102 E. Pikes Peak, Suite 500  
Colorado Springs, CO 80903  
(719) 955-5485

January 15, 2020

**RE: Homestead at Sterling Ranch Filing No.2  
Response to Comment Letter.**

HISTORIC, EXISTING AND PROPOSED DRAINAGE MAPS

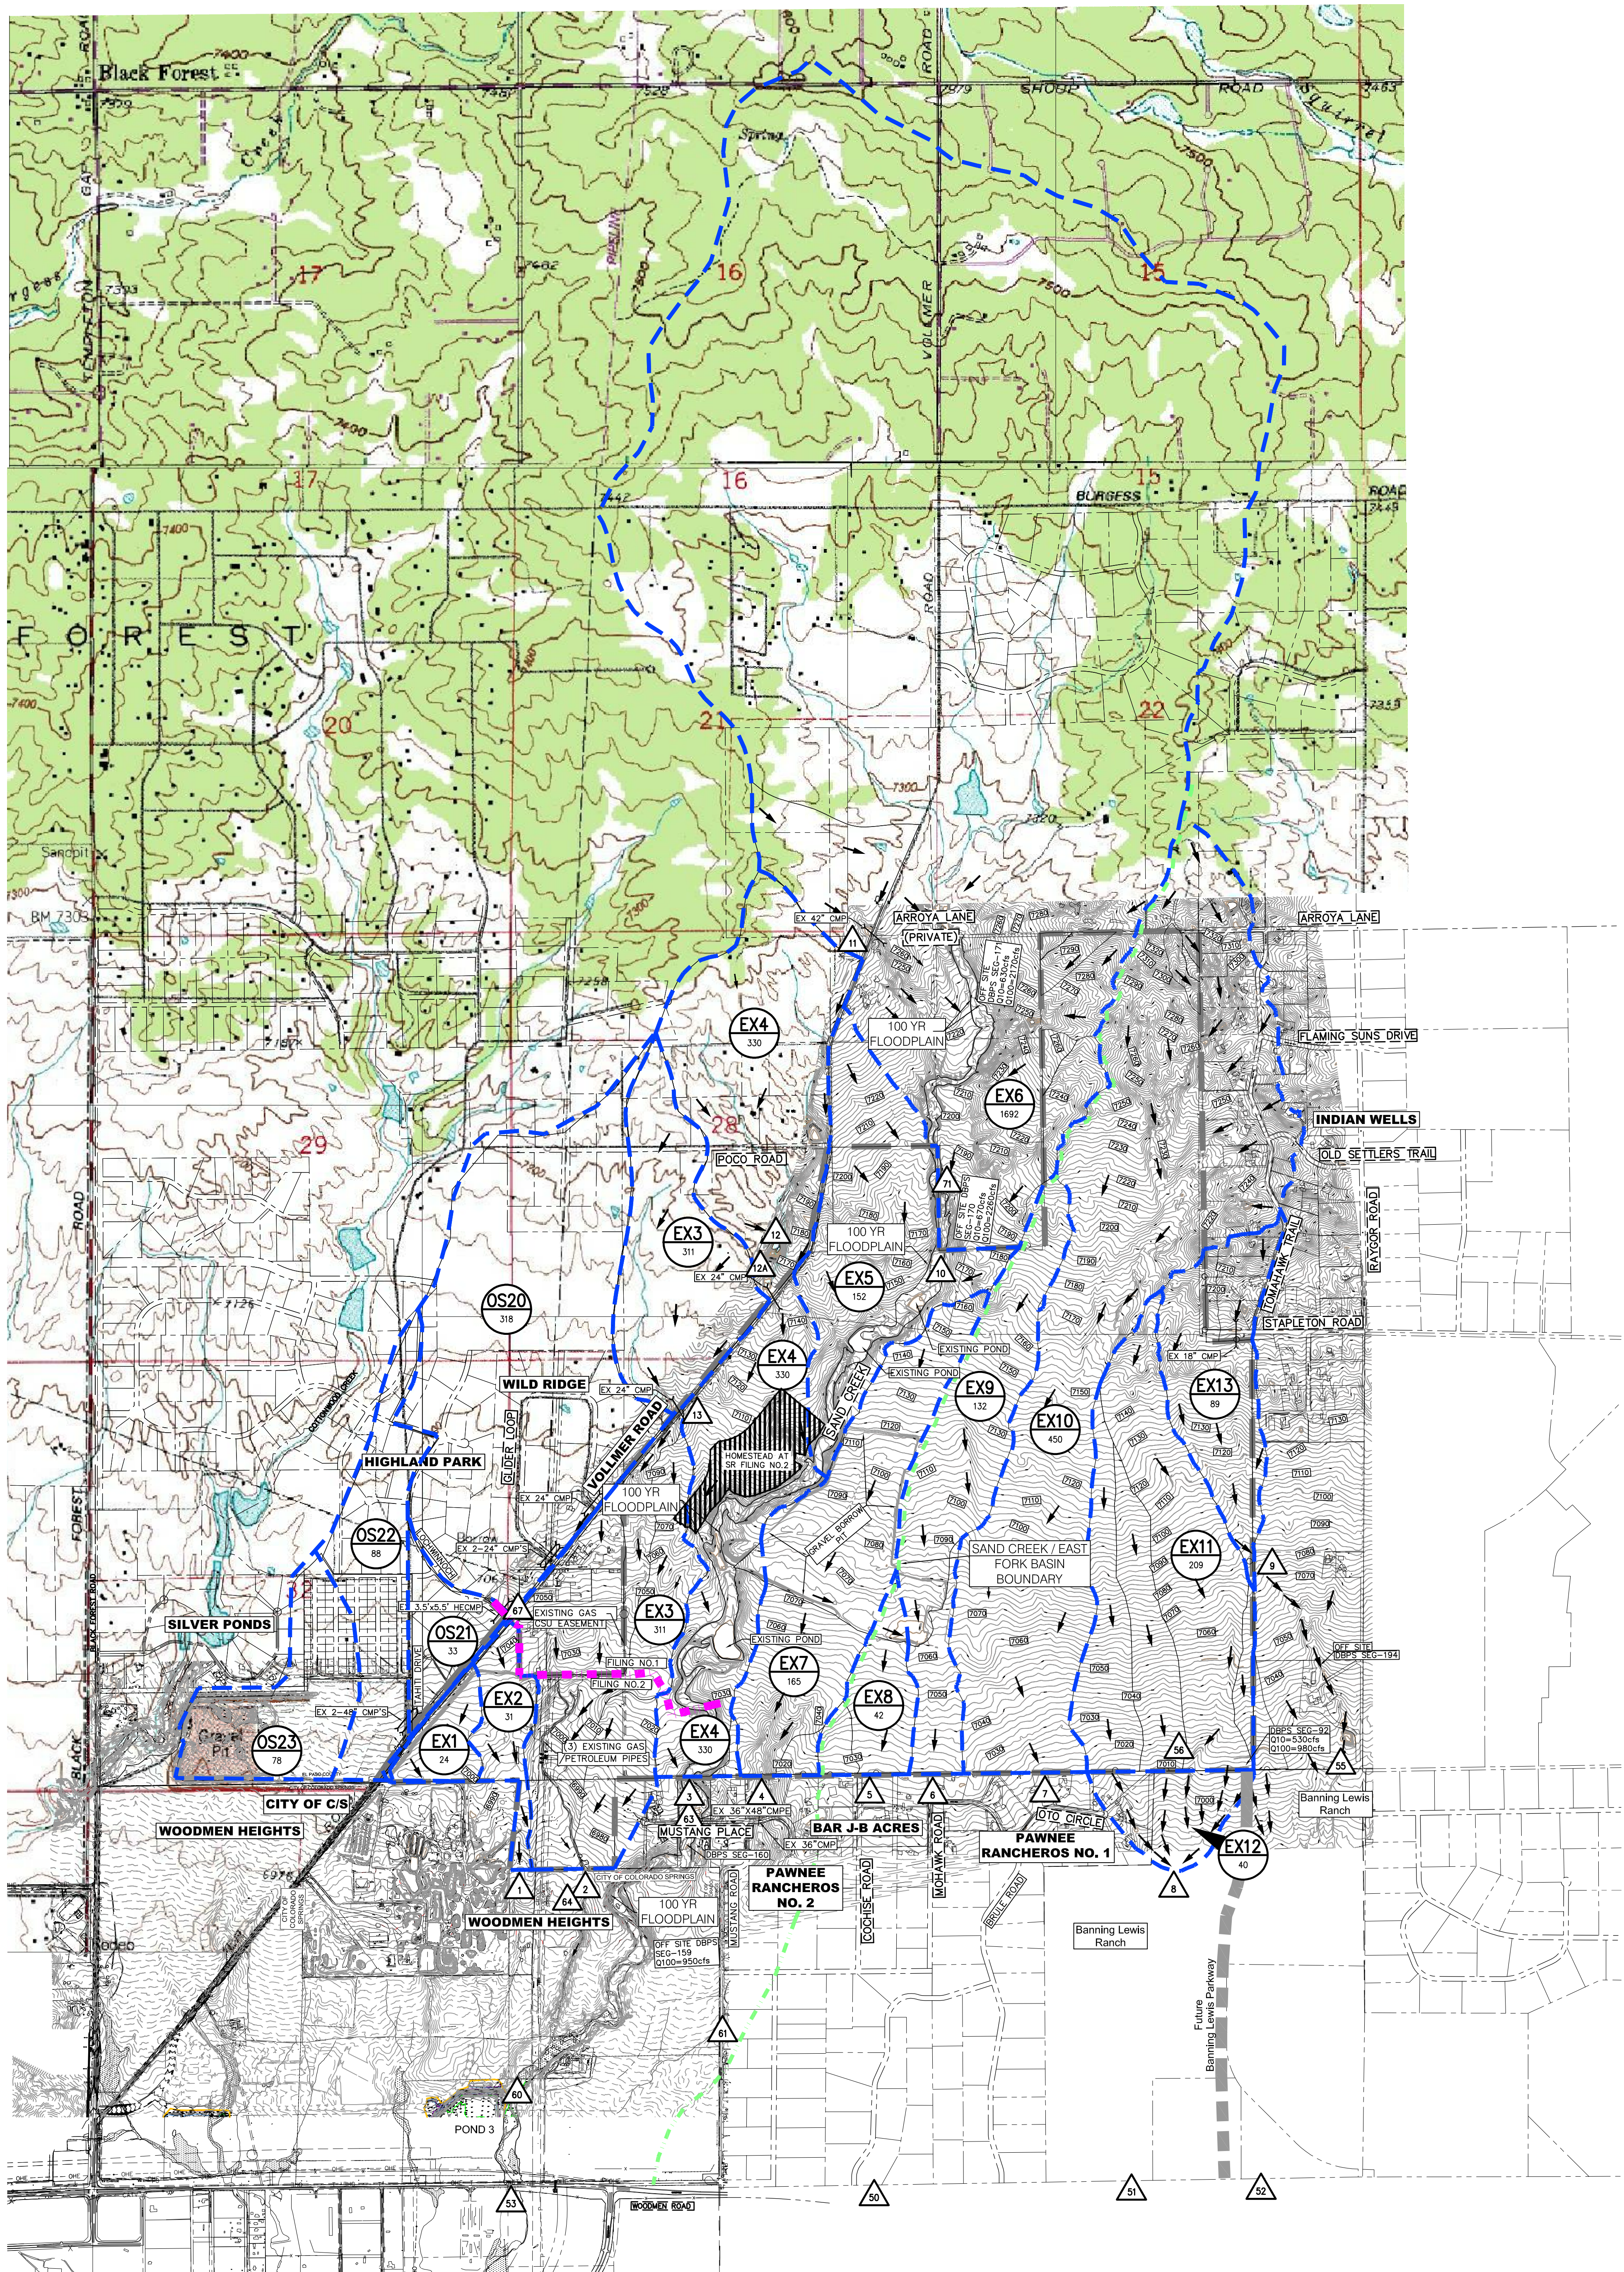
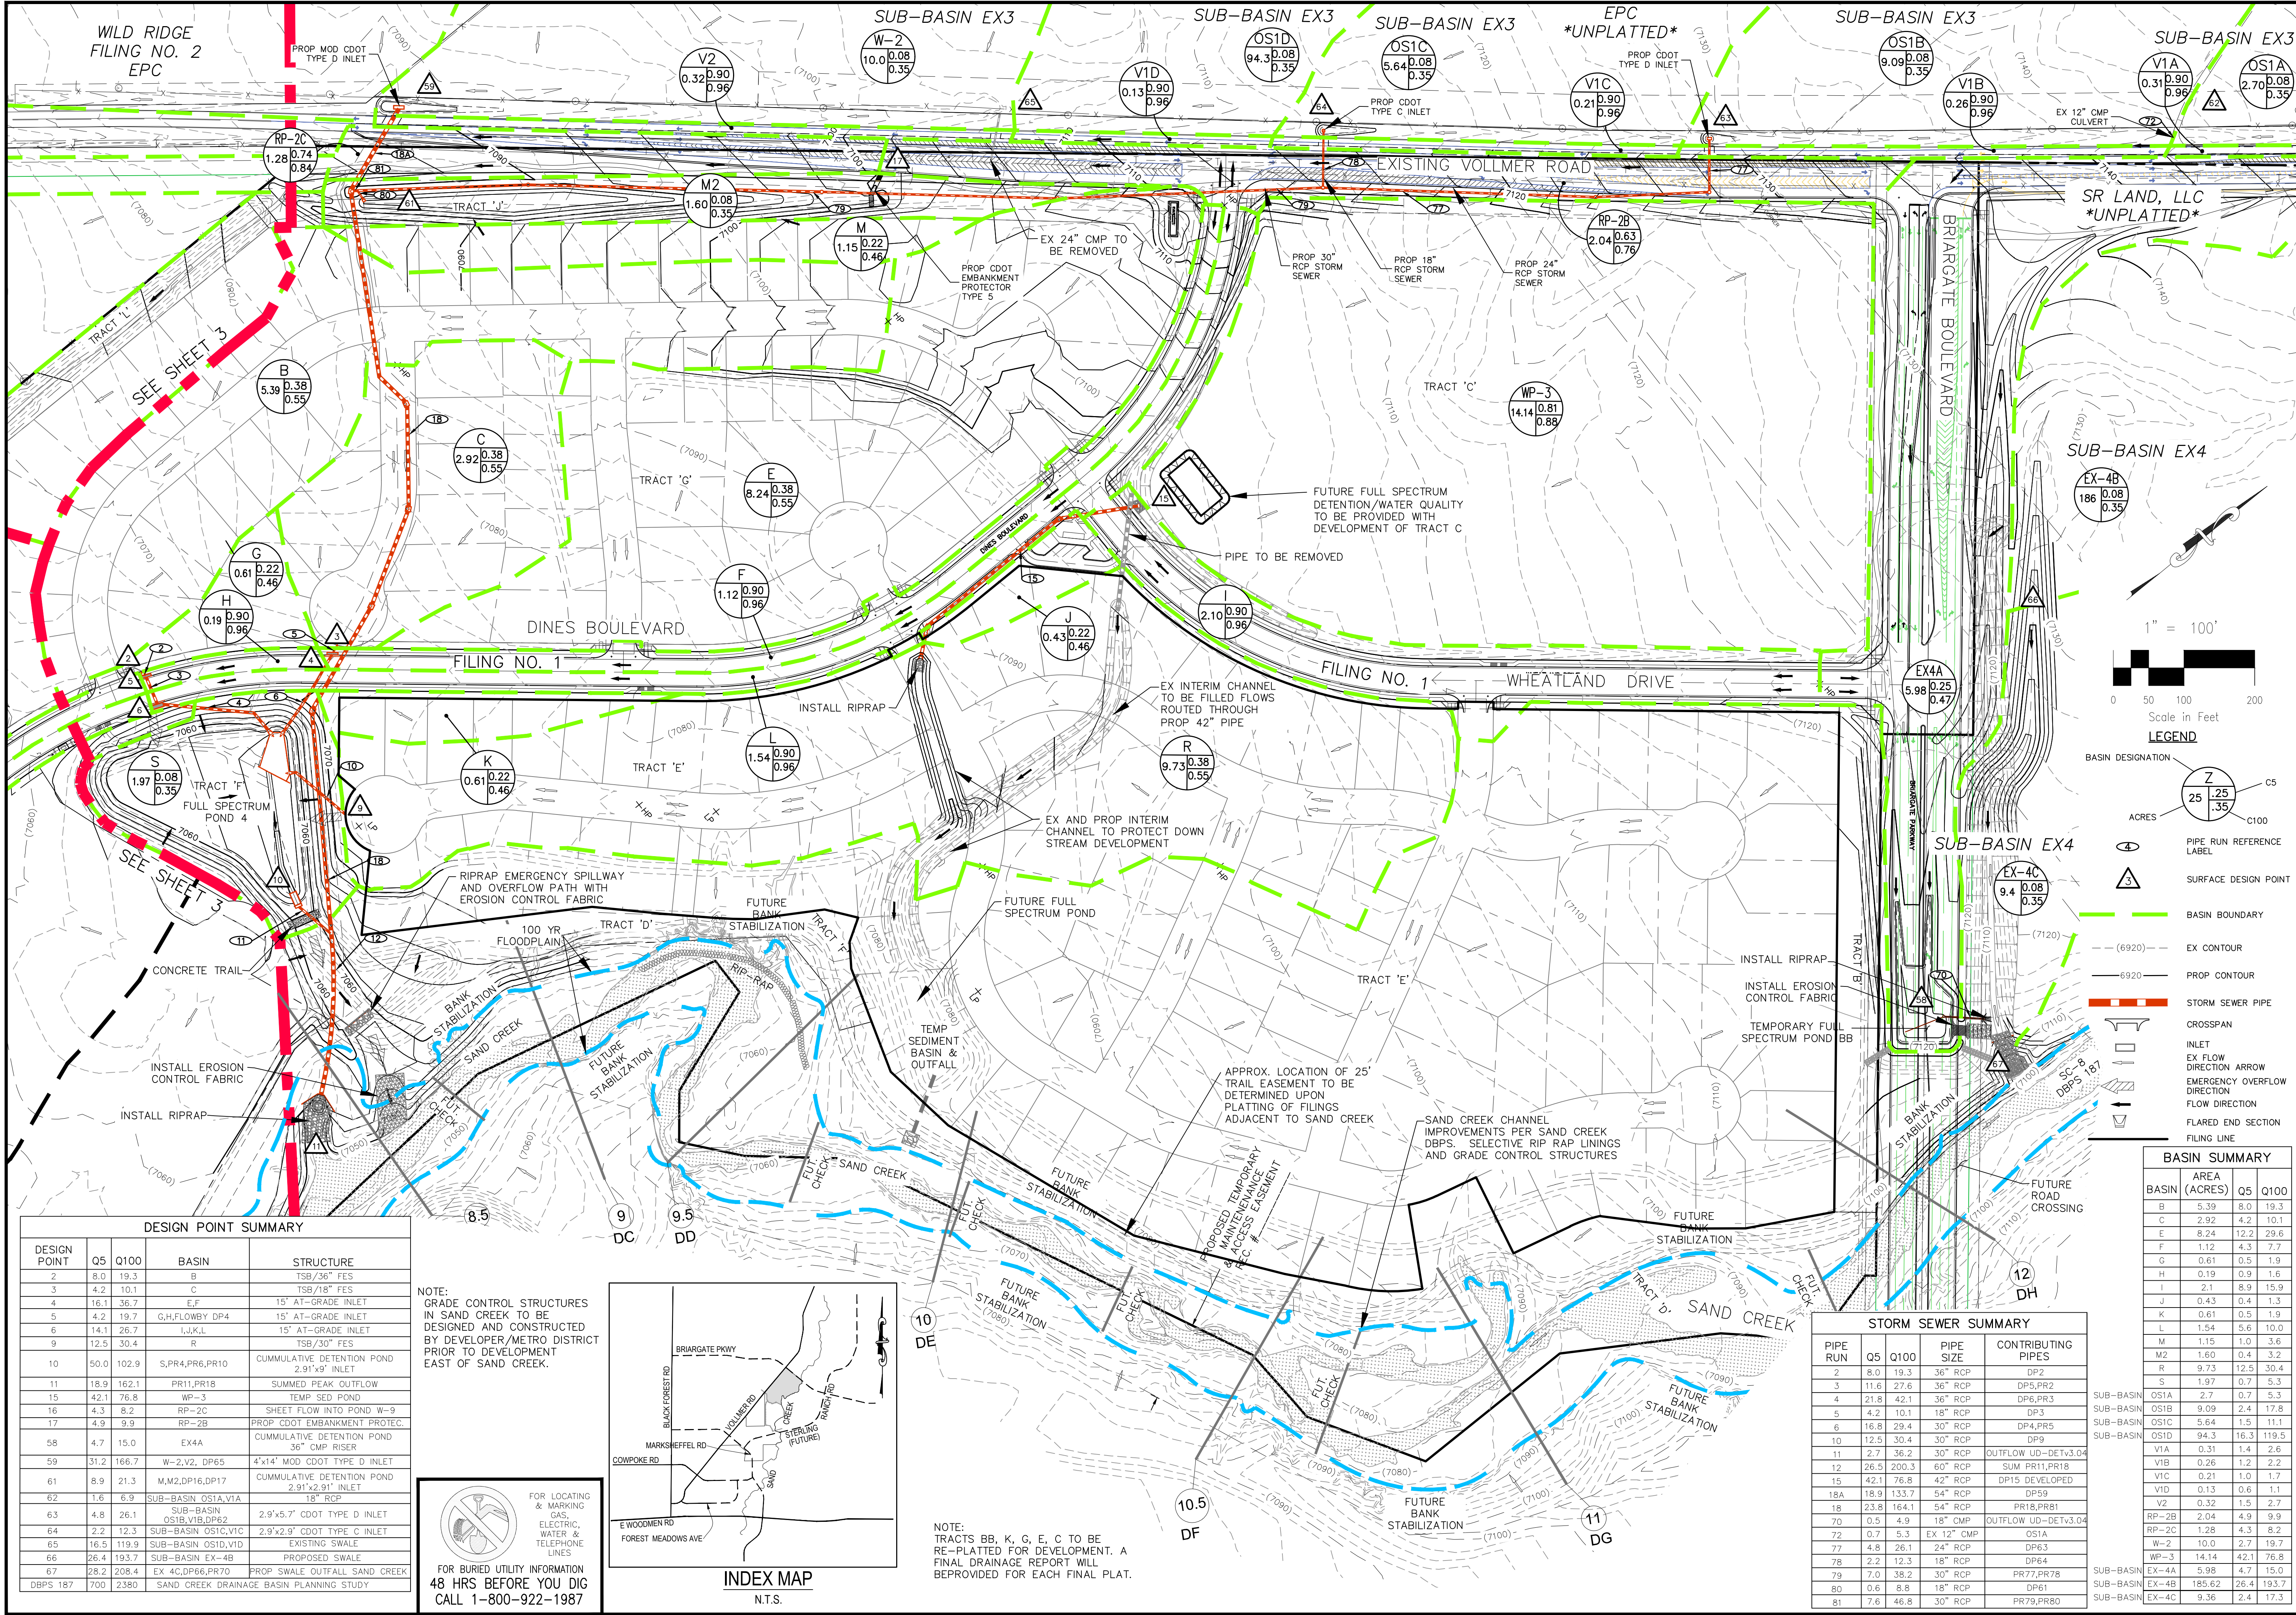
2. **Resolved.**
3. **Resolved.**
4. Provide an existing conditions drainage map per DCM Volume 1 criteria. **Unresolved. Done. See revised plan. Historic and existing conditions map provided.**

PROPOSED DRAINAGE MAP

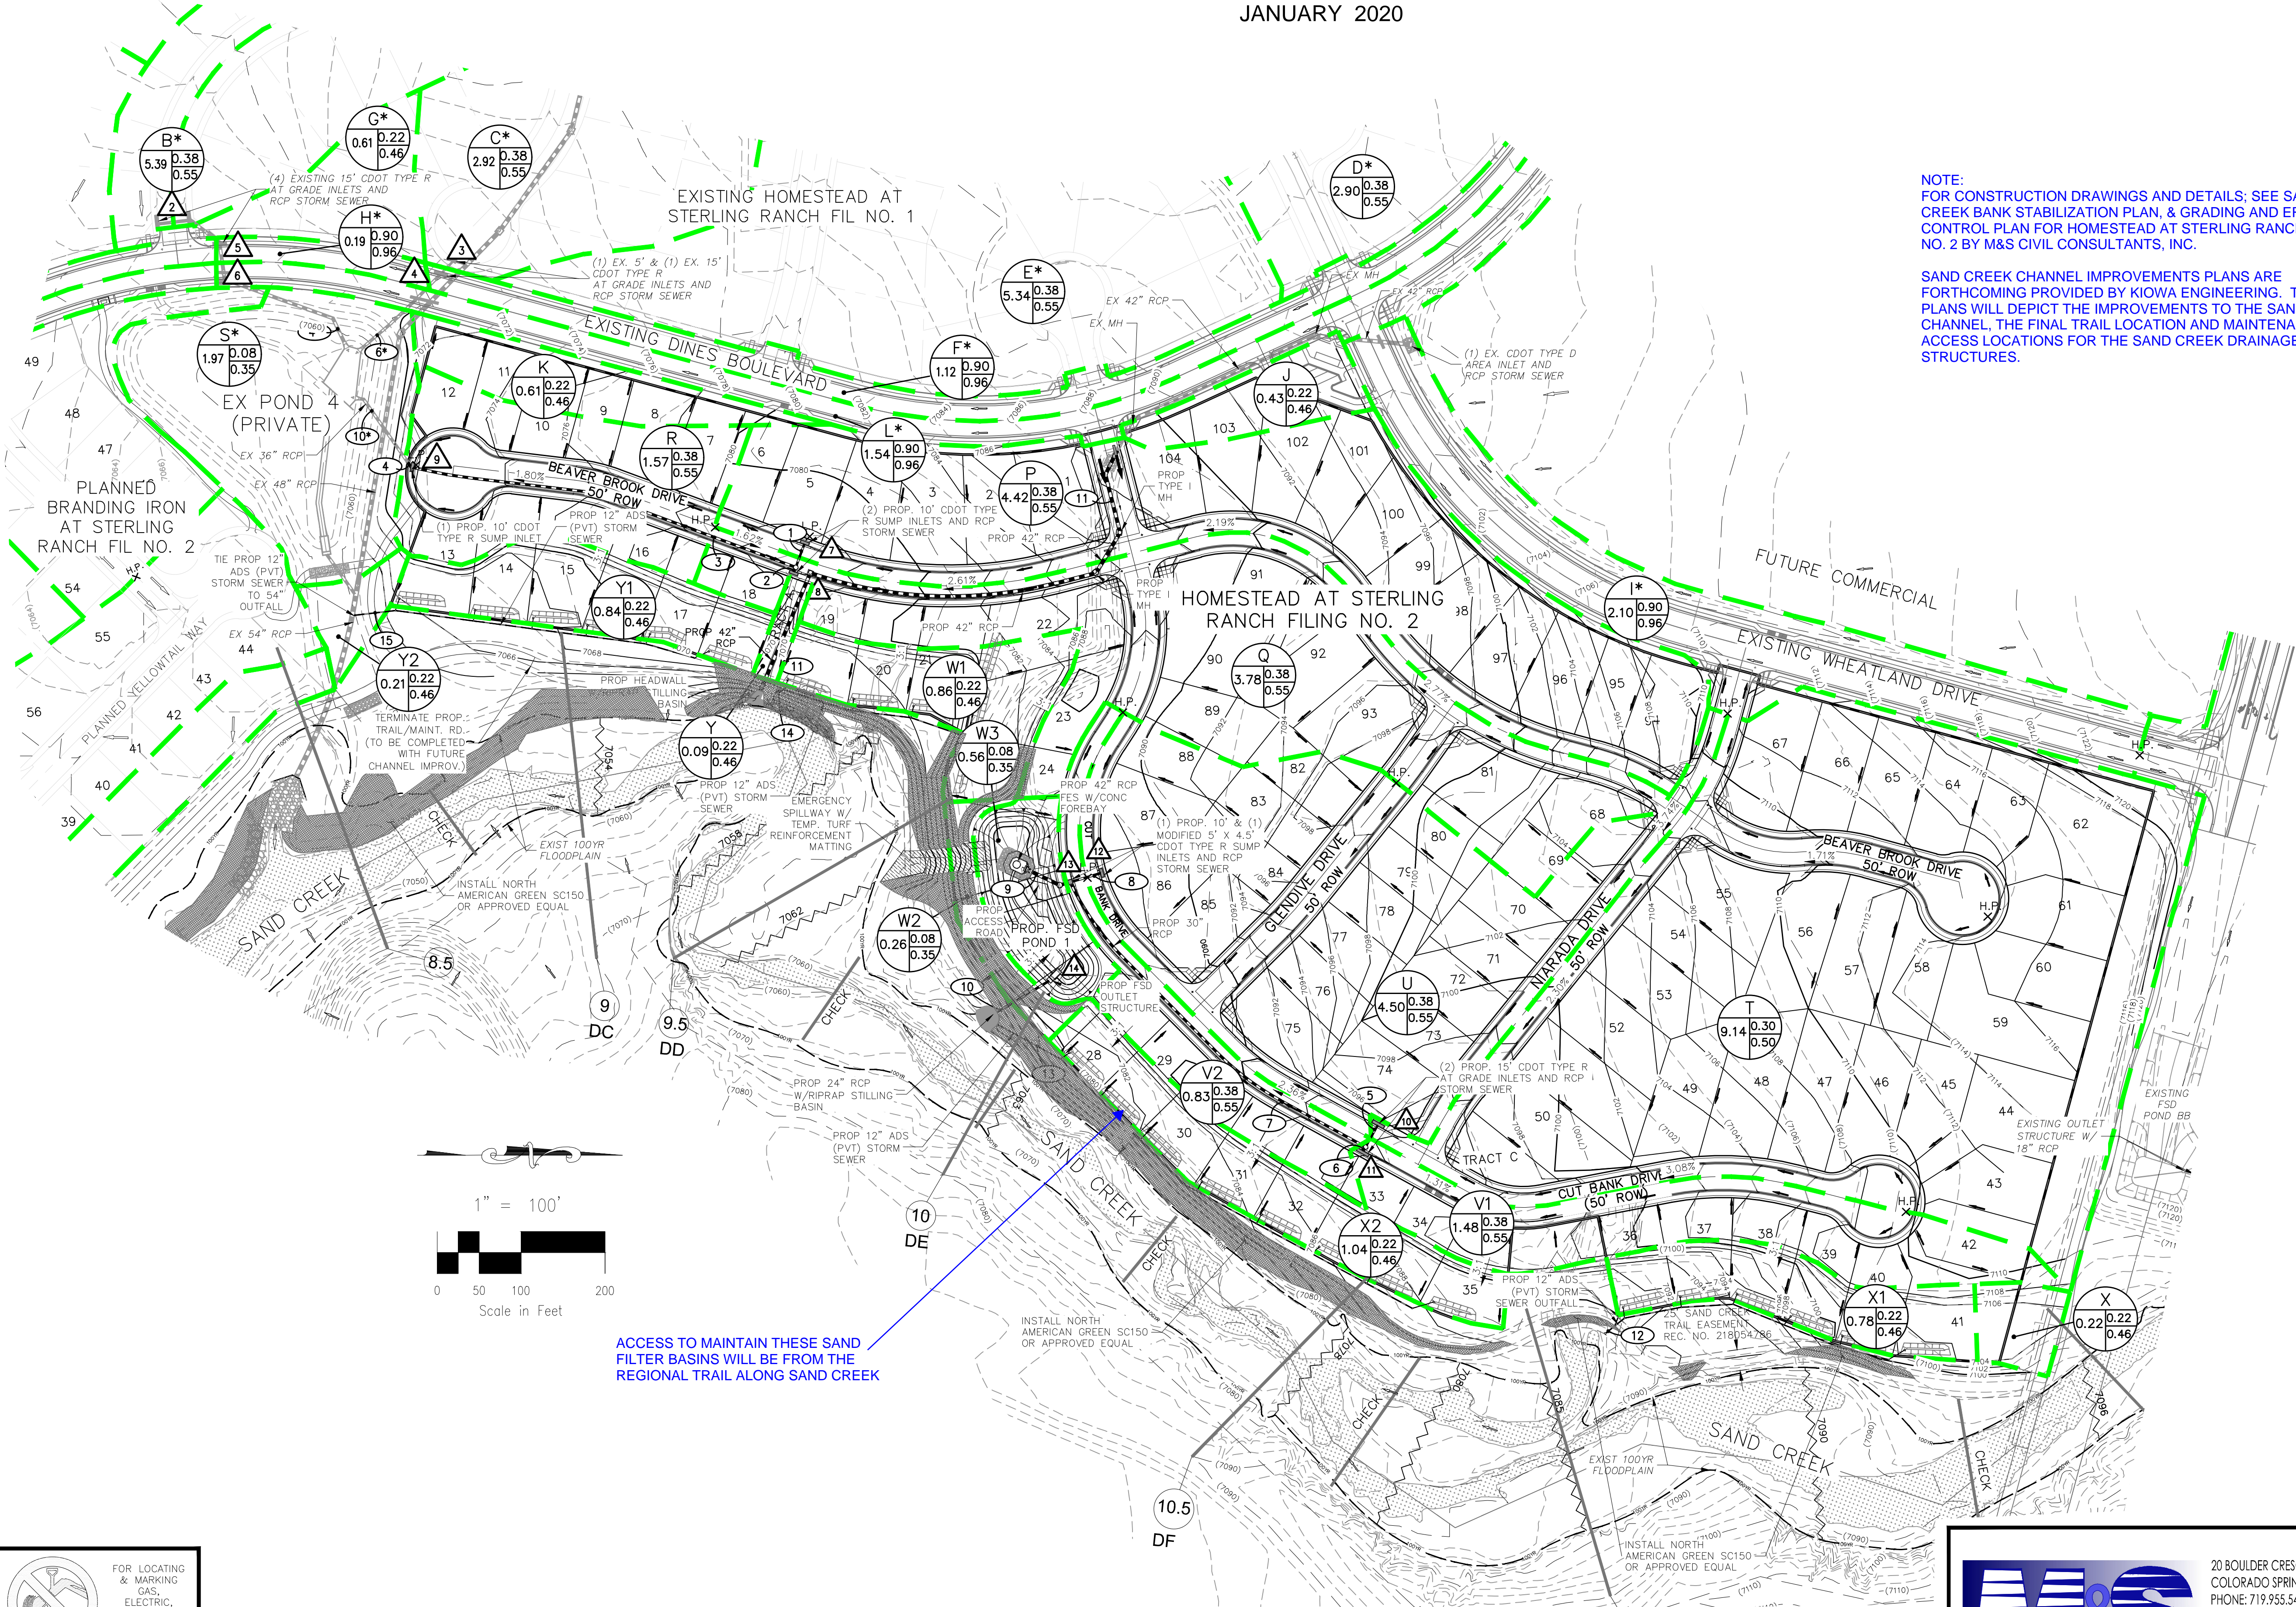
5. **Resolved.**
6. Label channel improvements adjacent to the proposed lots. **Unresolved; show and label all improvements on the drainage plan.**  
**The proposed channel improvements are shown on the drainage map. However, the final locations are subject to the final design. The proposed improvements are being shown for reference only.**

8. Clearly show and label all maintenance access roads and the trail on the plans.

**12 Summary comment addressed. Page 13 References comment addressed. EDB and SFB details provided in appendix. Historic and existing maps provided. Drainage map comments; proposed trail labeled. Maintenance road into pond shown and called out. Outlet structure stabilization and design per UDFCD Fig. 9-37 low tailwater riprap basin. Trail will be utilized to access and maintain SFB's.**

**The trails and maintenance road locations will be determined with the final design of the sand creek channel improvements at a later time.**
